Our Ref: EN010147

**Application by Photovolt Development Partners on behalf of Solar Five Limited (the  
Applicant) for an order granting development consent for the Botley West Solar  
Farm Project**

**Request for further information**

Project: AG1803	Sheet: Field 2.100
Date: November 2024	
Scale: 1 : 4000 @A3

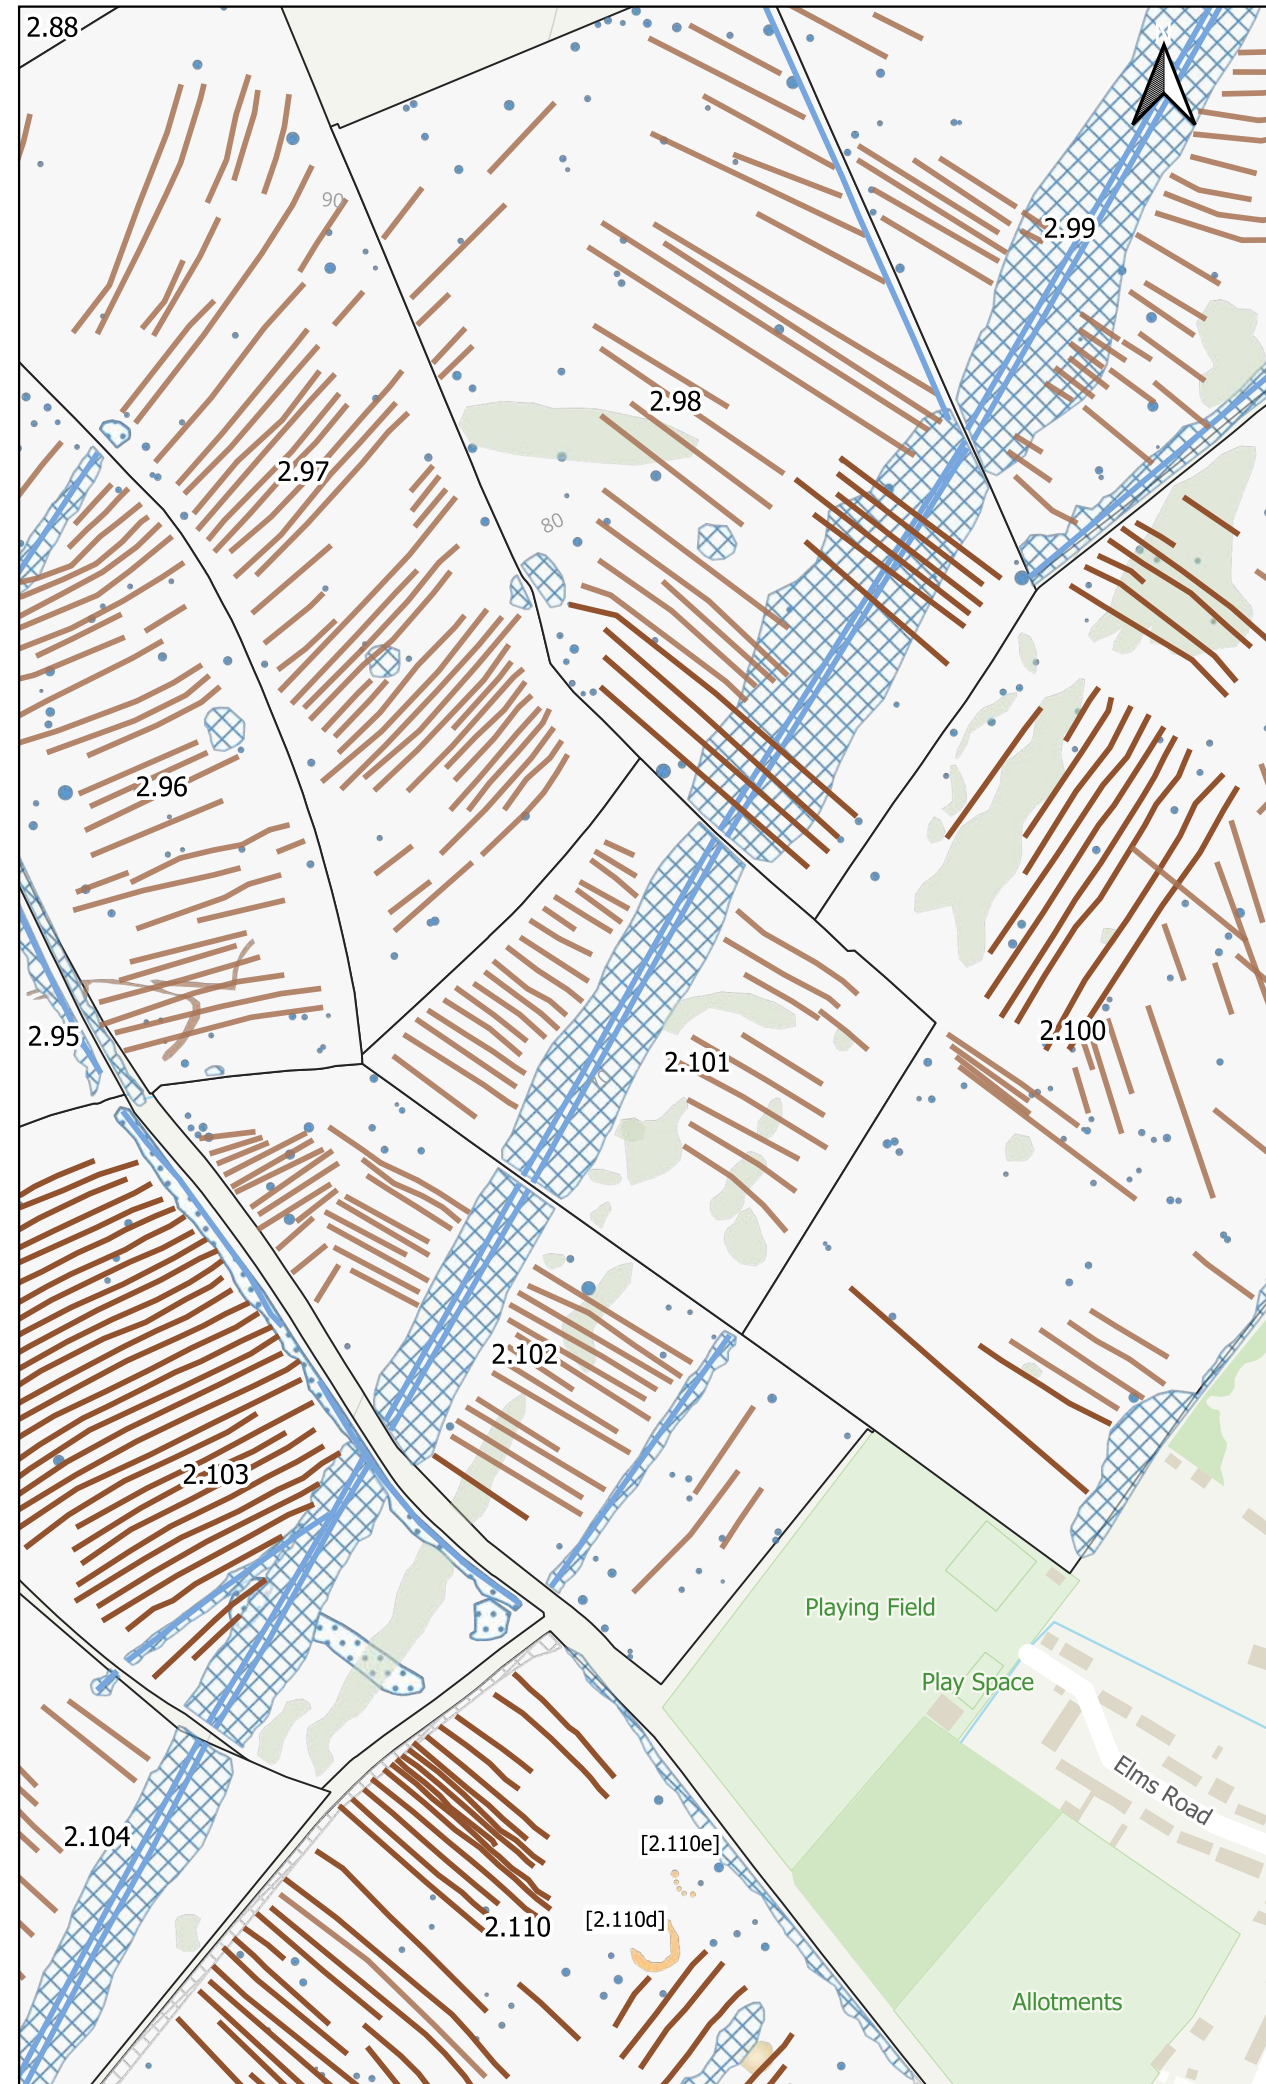
12. OHA and Historic England - It is acknowledged that the survey for the Central West Site, carried out by a different contractor, is still in draft form and that Appendix 2 of this report, the Summary of Geophysical Survey Results in particular, is missing detail. Notwithstanding this, at Table 2 the report notes 66 trenches with significant archaeological features and deposits located in the following field numbers. Therefore please comment on whether you consider greater buffers should be applied following this survey in relation to the following field numbers; those marked with an asterisk currently have no buffer zones proposed 2.63\*; 2.65\*; 2.66\*; 2.70; 2.78; 2.80\*; 2.84;

2.89\*; 2.92\*; 2.95\*; 2.100; 2.102\*; 2.103\*; 2.104; 2.110; 2.114; 2.115\*; 2.118\* and 2.57\*.
